# Non-Material Amendment Details

**Site:** 102-124 Station Road, Edgware HA8 7BJ

**Job No:** 14775-1

Drawing Title: Block D - First and Second Floor Plans

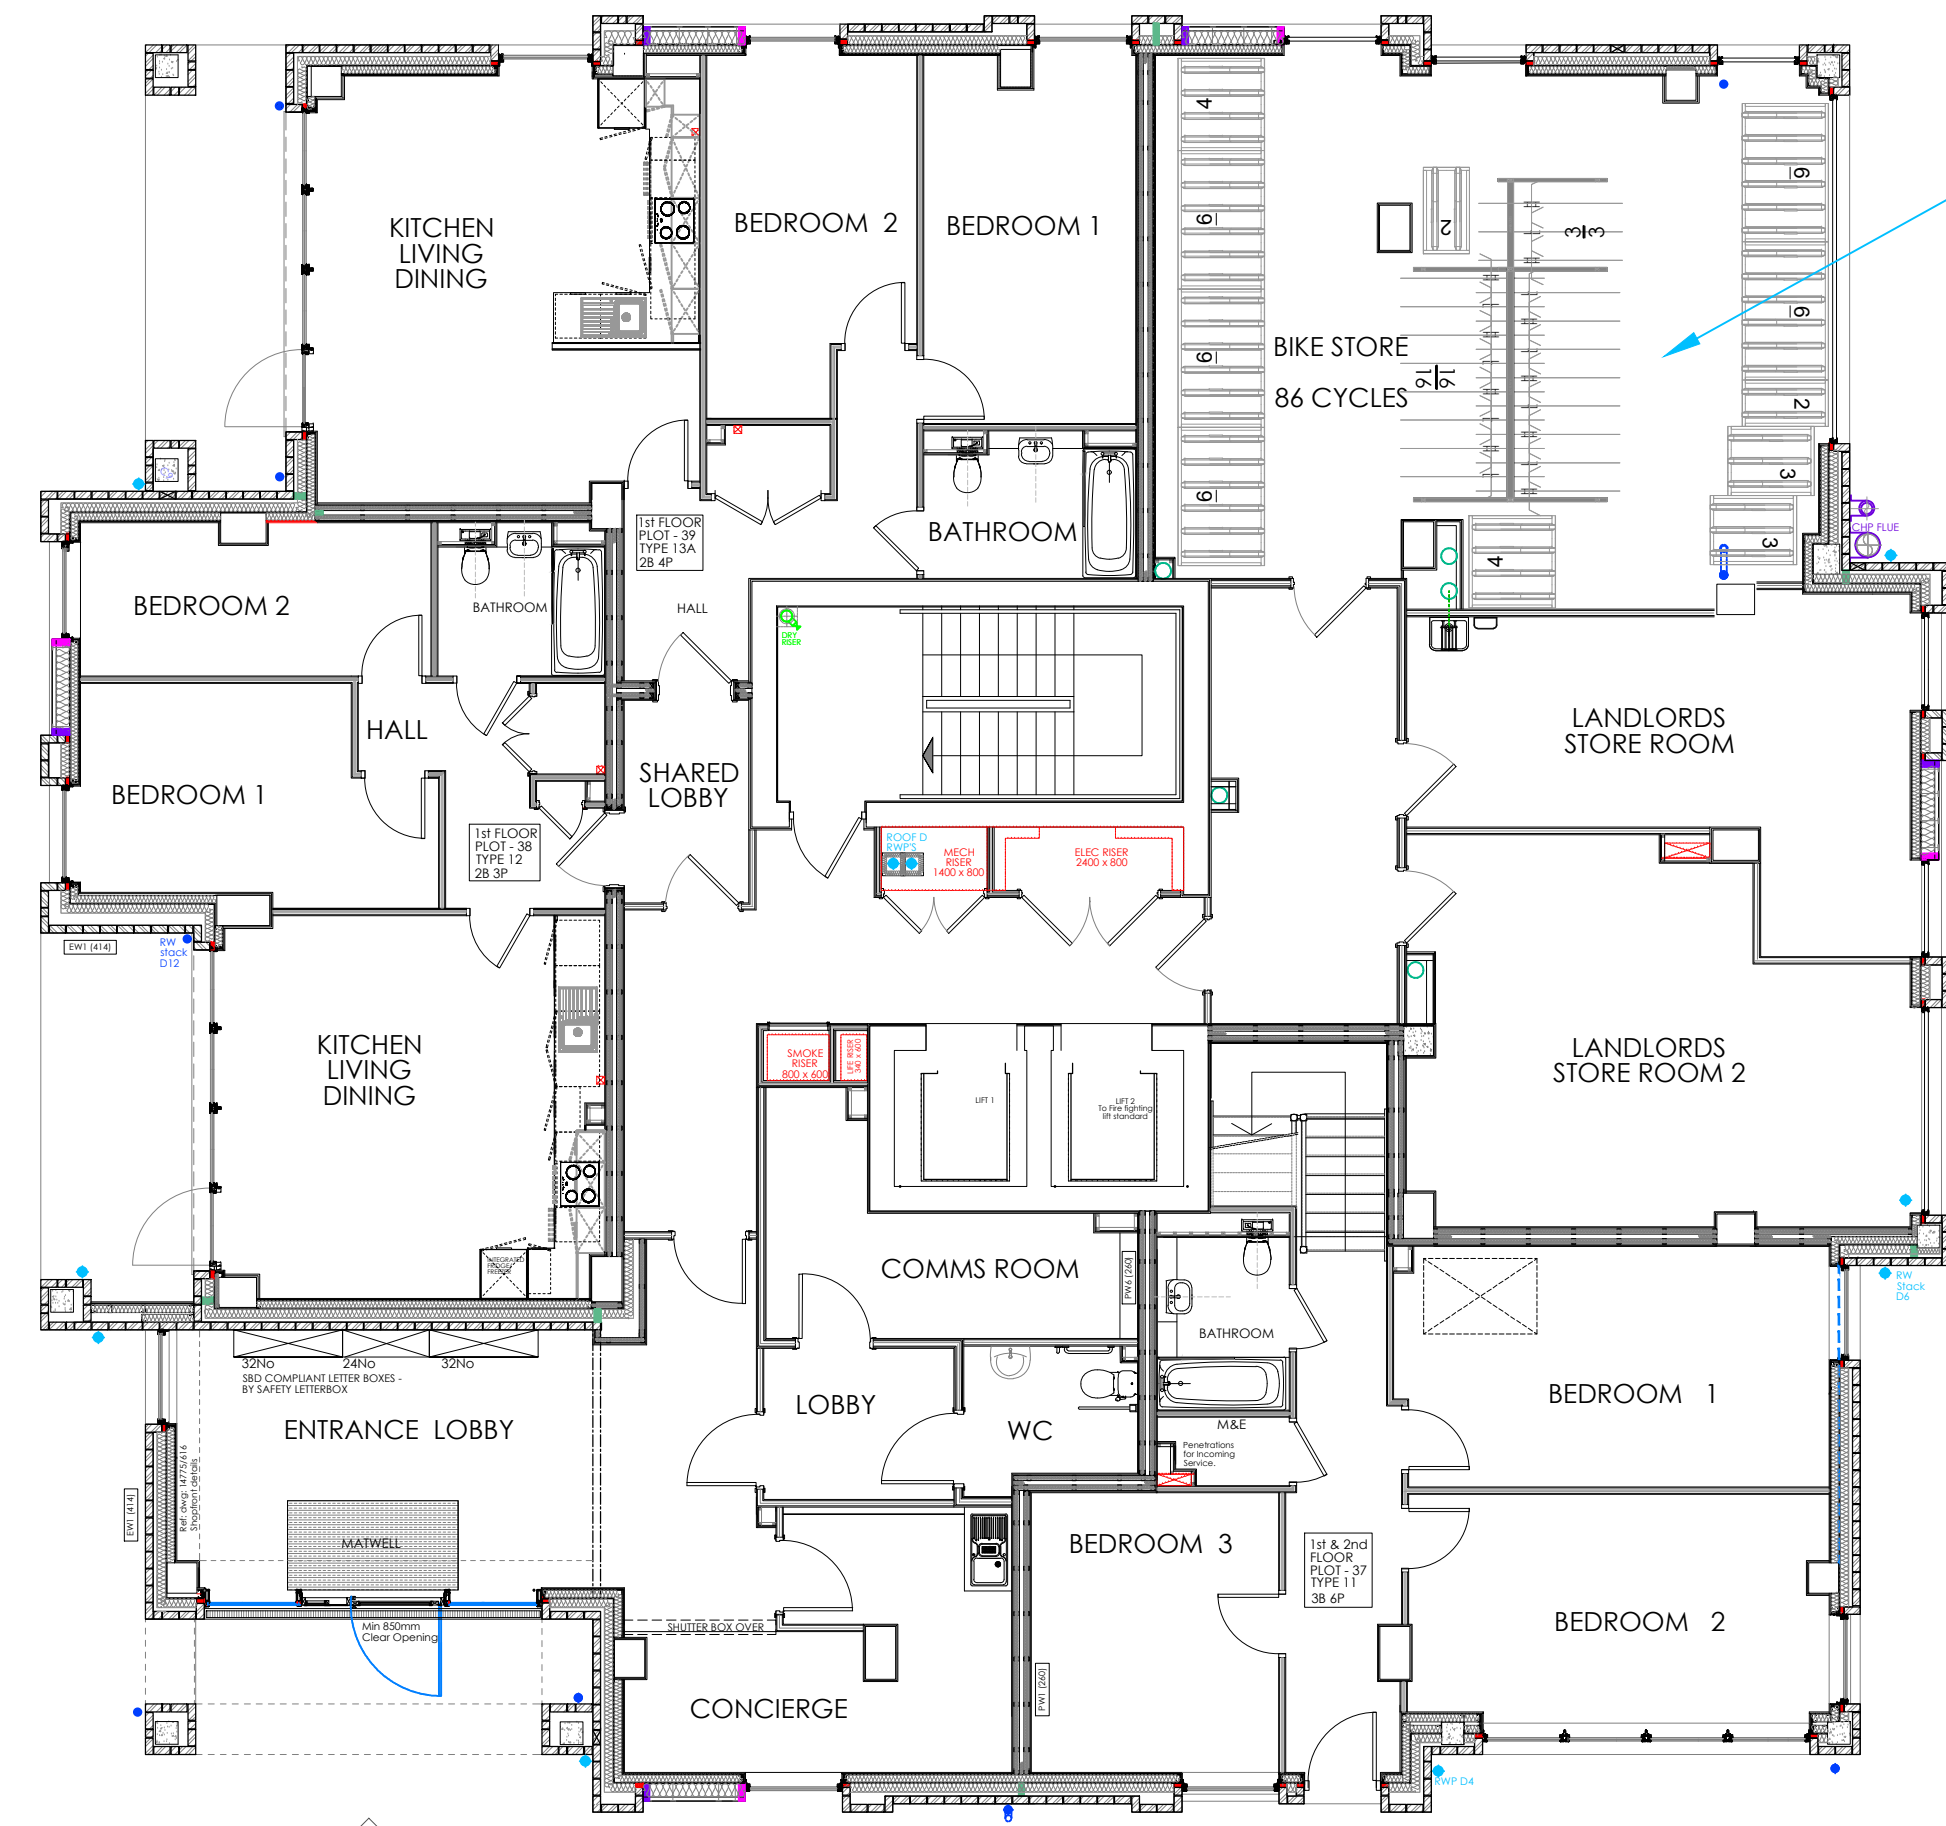
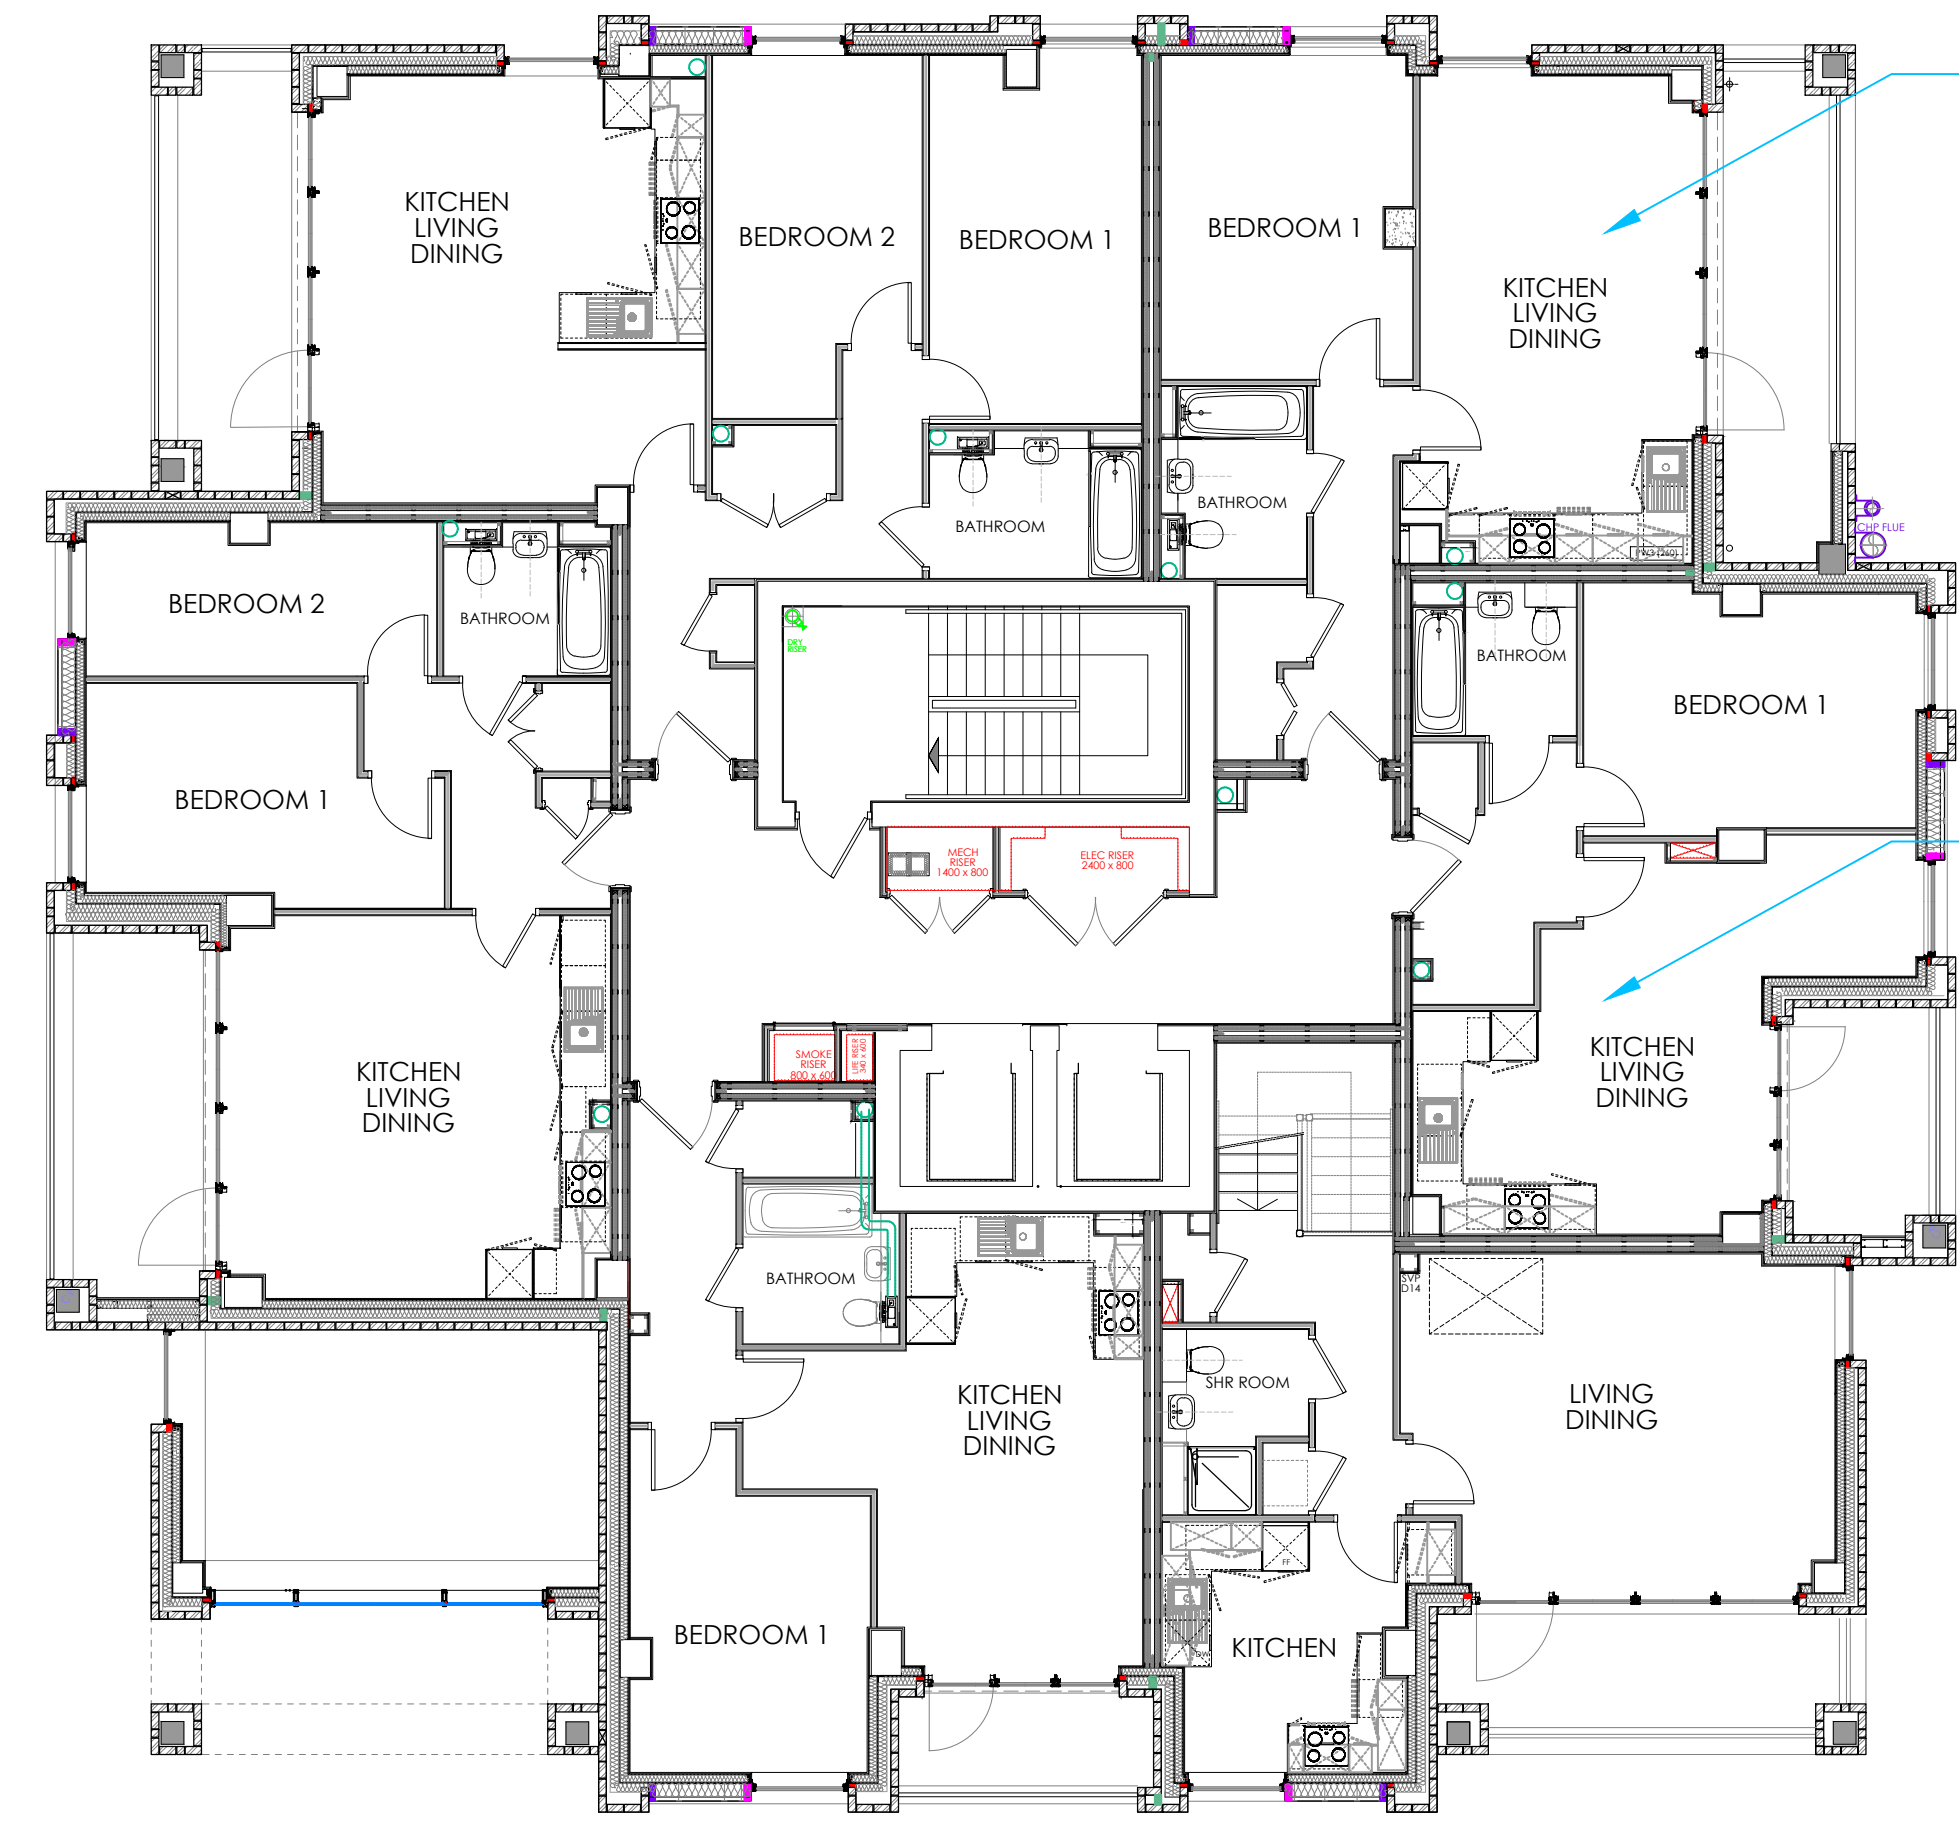
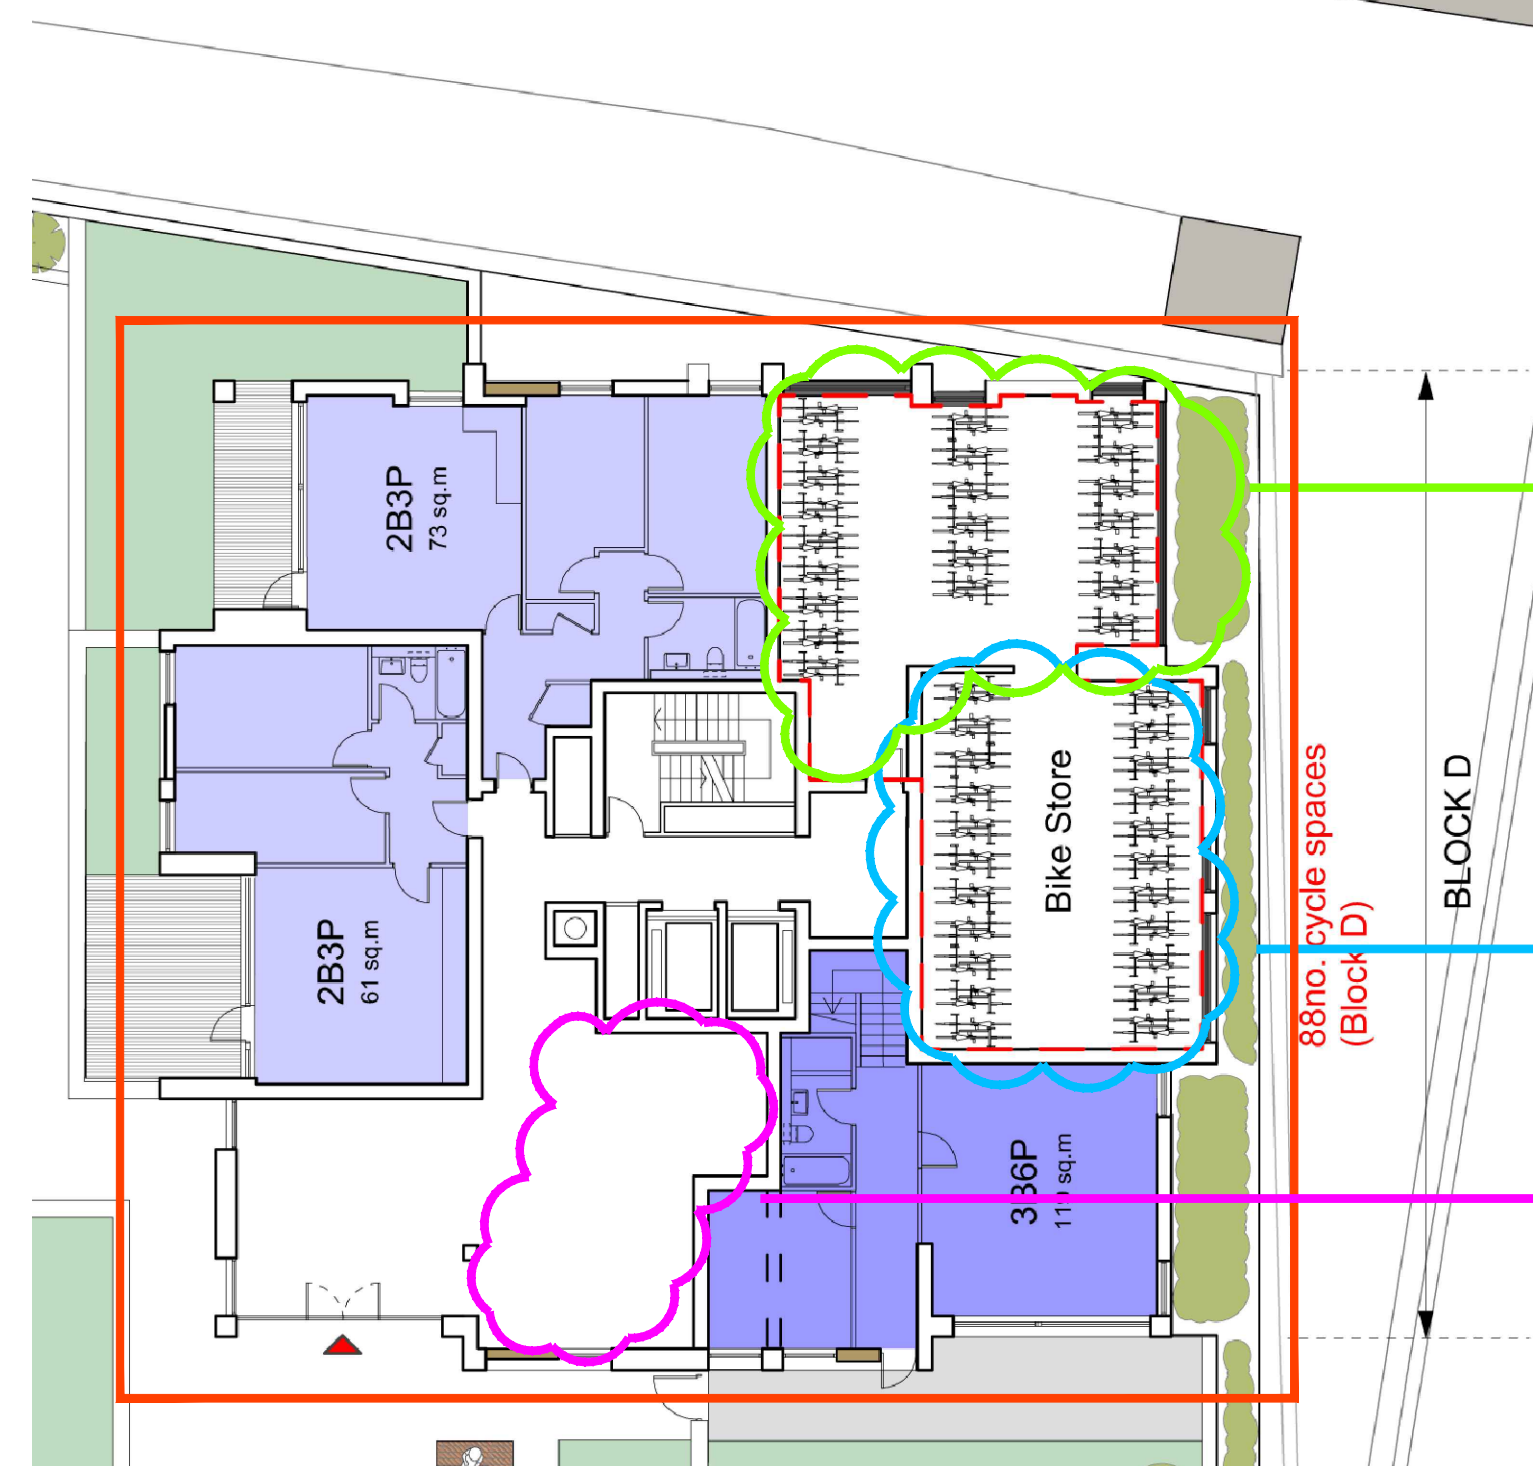
Two additional flats have been added to the 2nd floor layout of block D in place of a cycle store with 44 spaces and a storeroom. The total number of flats in the development will increase from 122 to 124.

Added to the 1st floor level of block D, are a revised cycle store with 86 spaces, Two new landlords' storerooms and new concierge facilities. This is in place of a cycle storage area with 88 spaces and a segment of a large lobby space for the concierge.
